3 July 2020

SSD 6687: Uungula Wind Farm

Transport for NSW

Figure 1 | Road Upgrades Summary

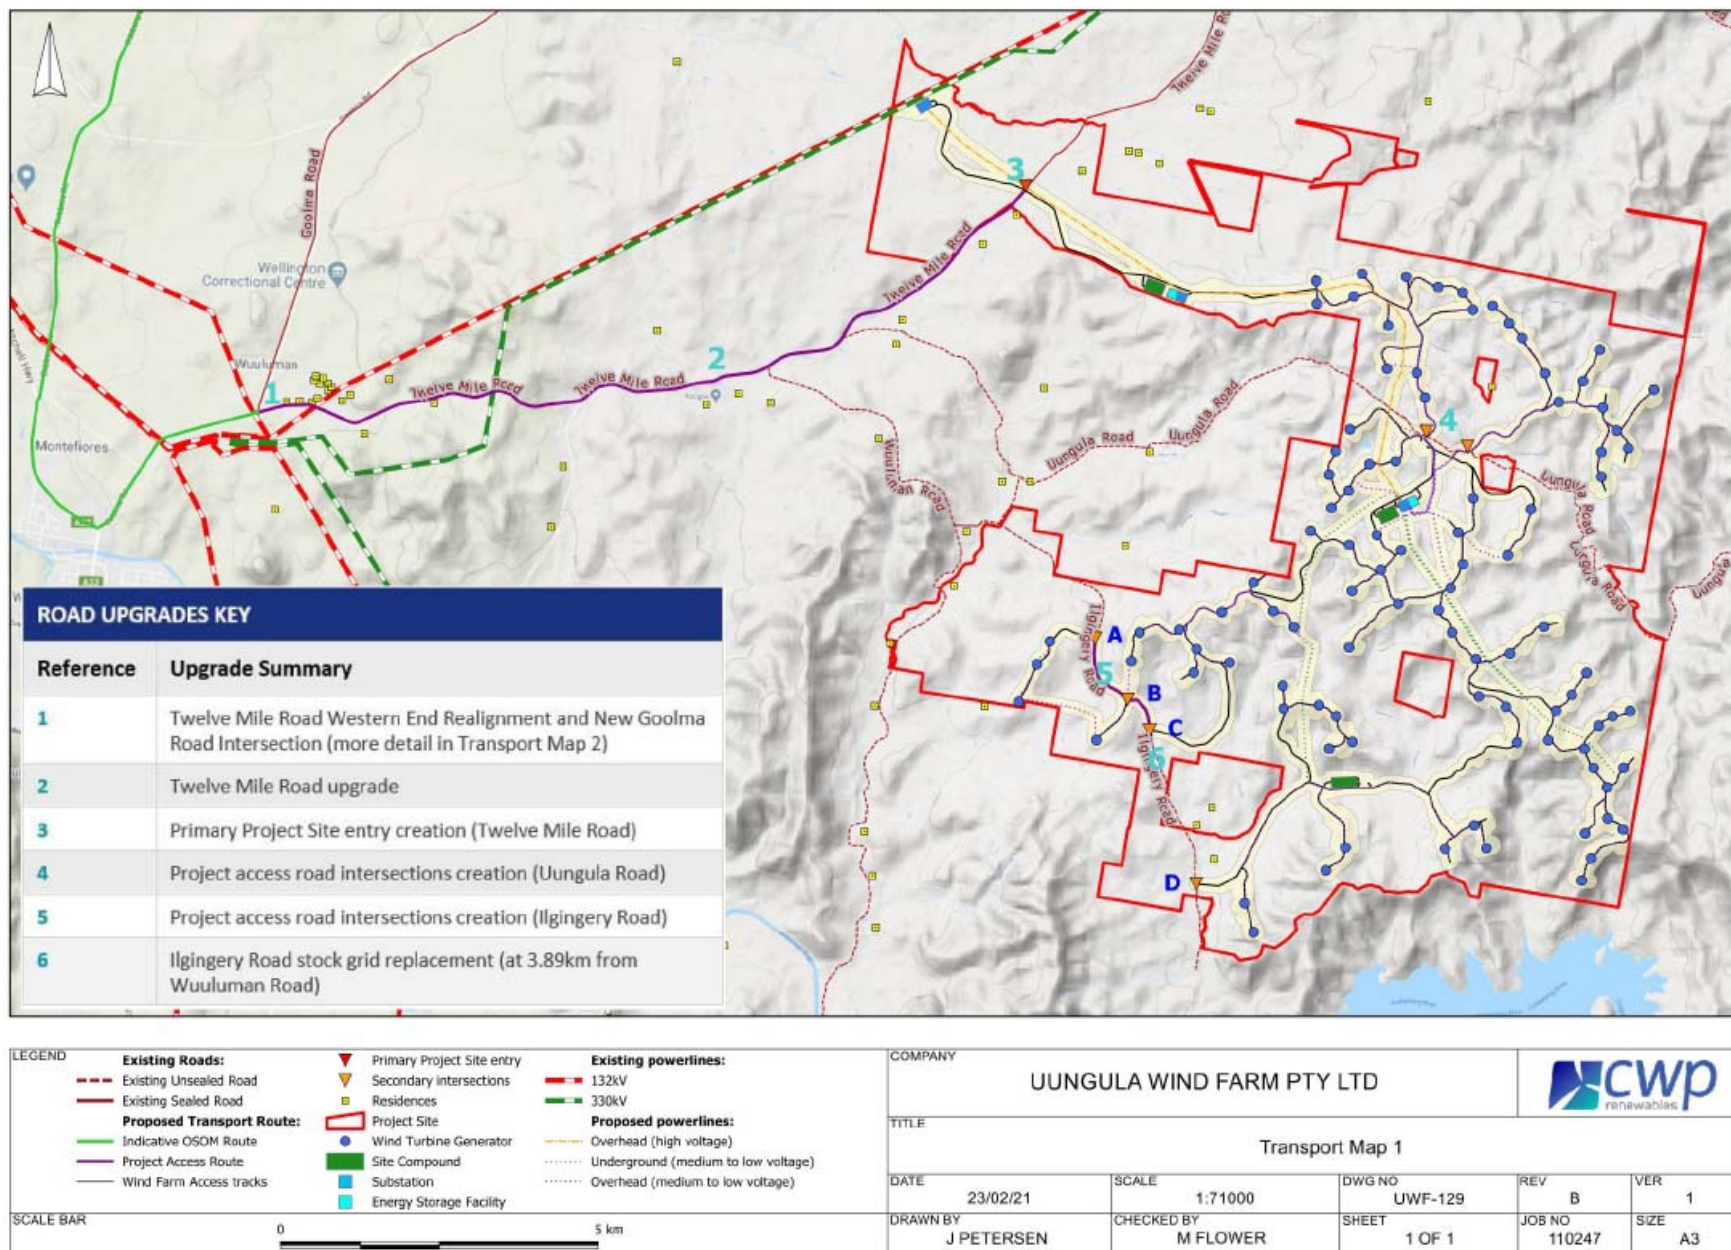
- Details and concept designs of proposed upgrades to local roads (including Twelve Mile Road and Uungula Road) to facilitate the safe passage of traffic generated by the proposed wind farm and existing background traffic. Specifically, the concept designs need to show lane widths, road pavement, location of passing bays and required works to facilitate the upgrade.

Figure 2 | Twelve Mile Road / Goolma Road Intersection Design

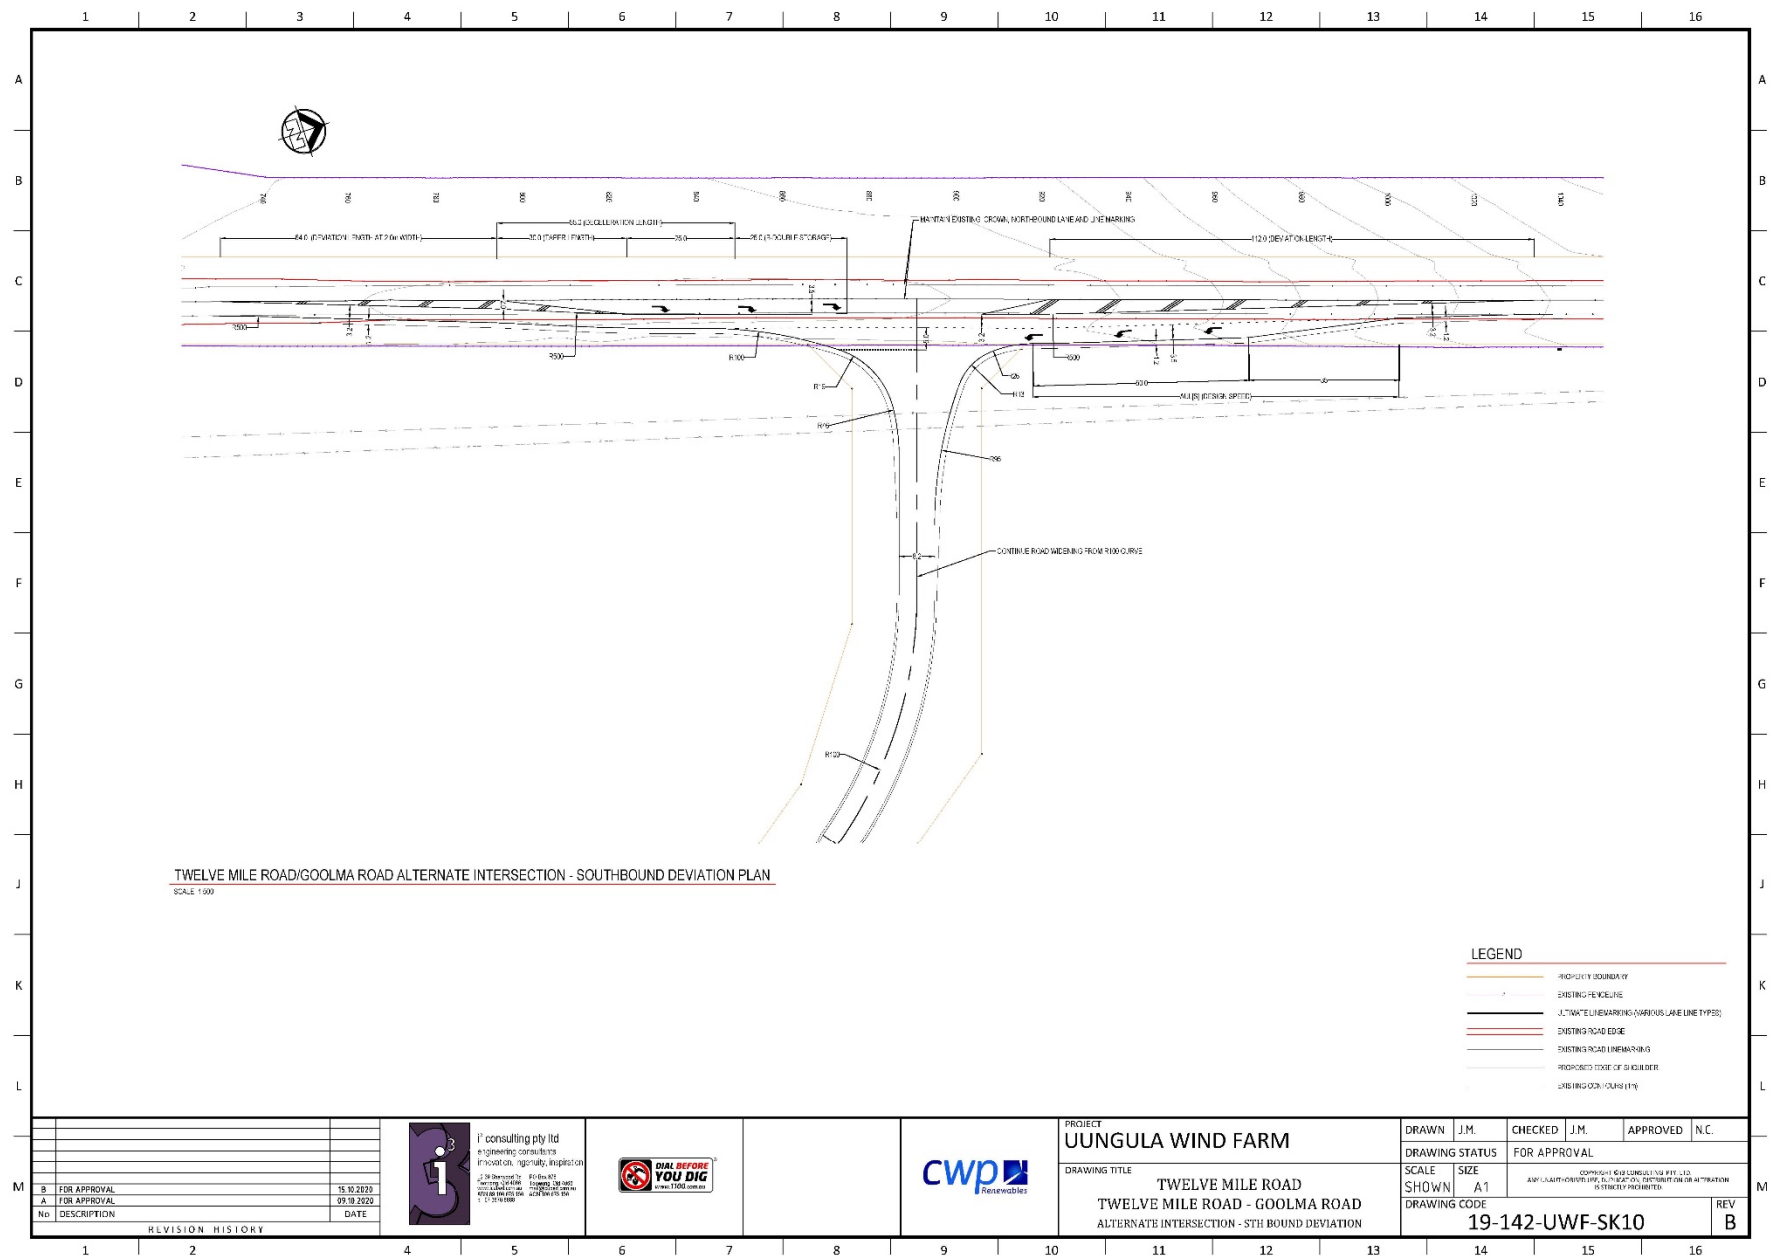
- To facilitate safe light and heavy vehicle access from and to Goolma Road, the intersection of Twelve Mile Road (west) and Goolma Road is to be upgraded generally in accordance with *Austroads Guide to Road Design* and relevant TfNSW supplements. In this regard, the proponent is required to develop an intersection upgrade design to the satisfaction of Dubbo Regional Council and TfNSW. The design will need to include details of existing and proposed levels, lane widths and earthworks required to achieve a safe and efficient intersection.

Note: All construction and maintenance vehicle access and egress to the wind farm site from Goolma Road is to be via the upgraded intersection of Twelve Mile Road (west) and Goolma Road. Vehicular access via alternate routes between the site and Goolma Road are not permitted.
